Planning and Development Services
Arun District Council
Arun Civic Centre
Maltravers Road
Littlehampton
West Sussex
BN17 5LF

Proposal: New concrete skate park with 4 No. floodlighting & new parkour training facility. This application is a Departure from the Development Plan.
Site: Littlehampton, Skate Park Sea Road, Littlehampton, BN16 2NA.
LU/136/19/PL

Southern Water Developer Services, Sparrowgrove House, Sparrowgrove, Otterbourne, Winchester, Hampshire, SO21 2SW
southernwater.co.uk

Project					LITTLEHAMPTON				
Title					SURFACE DRAINAGE PLAN				
REV DRAINAGE PLAN 3									
Drawn			Dwg. Chk.		Date Chk.		Approved		Date Approv.
1:100@A1			Status			FC		Rev	
								*	
Drawing No.									
003

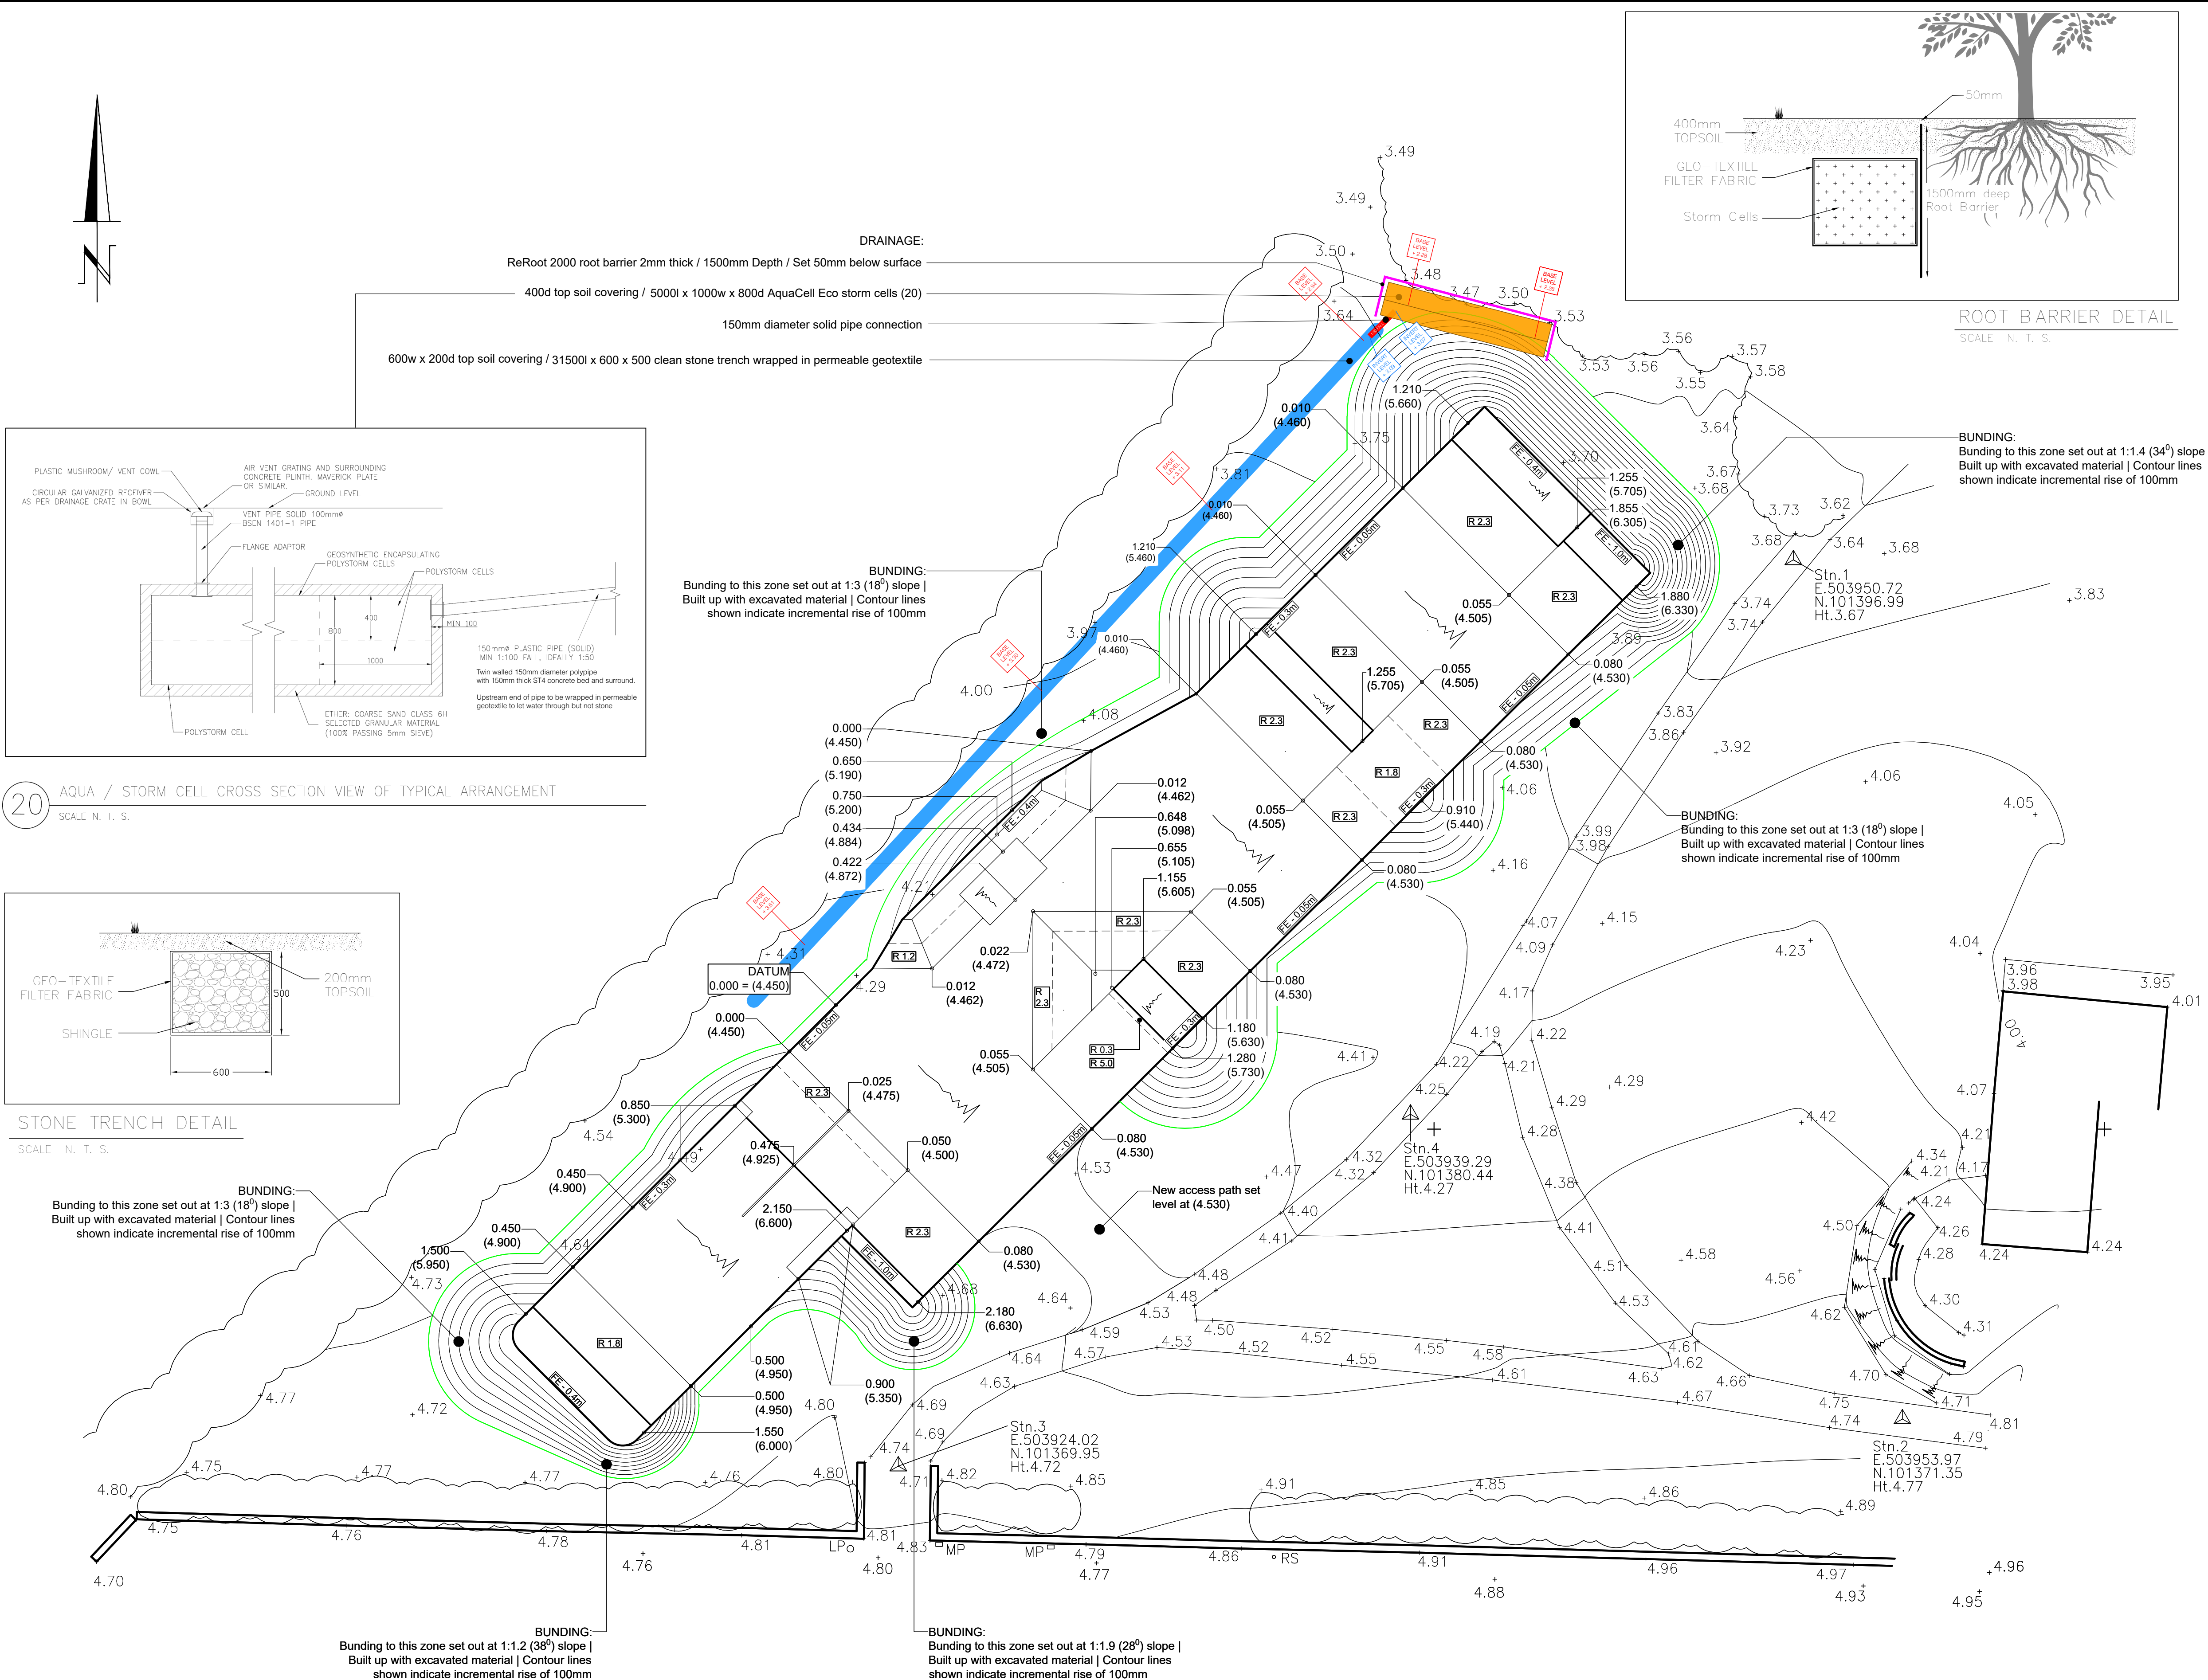
- No new development or new tree planting should be located within 3.5 metres either side of the external edge of the 700mm rising main.
- No new development or new tree planting should be located within 3.5 metres either side of the external edge of the 500mm rising main.
- No development or new tree planting should be located within 3.5 metres either side of the external edge of the 450mm public combined sewer.
- No new soakaways should be located within 5m of a public sewer.

The planning application form makes reference to drainage using Sustainable Urban Drainage Systems (SUDS).

Under current legislation and guidance SUDS rely upon facilities which are not adoptable by sewerage undertakers. Therefore, the applicant will need to ensure that arrangements exist for the long term maintenance of the SUDS facilities. It is critical that the effectiveness of these systems is maintained in perpetuity. Good management will avoid flooding from the proposed surface water system, which may result in the inundation of the foul sewerage system. Thus, where a SUDS scheme is to be implemented, the drainage details submitted to the Local Planning Authority should:

Land uses such as general hardstanding that may be subject to oil/petrol spillages should be drained by means of oil trap gullies or petrol/oil interceptors.

The design of drainage should ensure that no land drainage or ground water is to enter public sewers network.

Specify the responsibilities of each party for the implementation of the SUDS scheme

Specify a timetable for implementation

Provide a management and maintenance plan for the lifetime of the development. This should include the arrangements for adoption by any public authority or statutory undertaker and any other arrangements to secure the operation of the scheme throughout its lifetime.
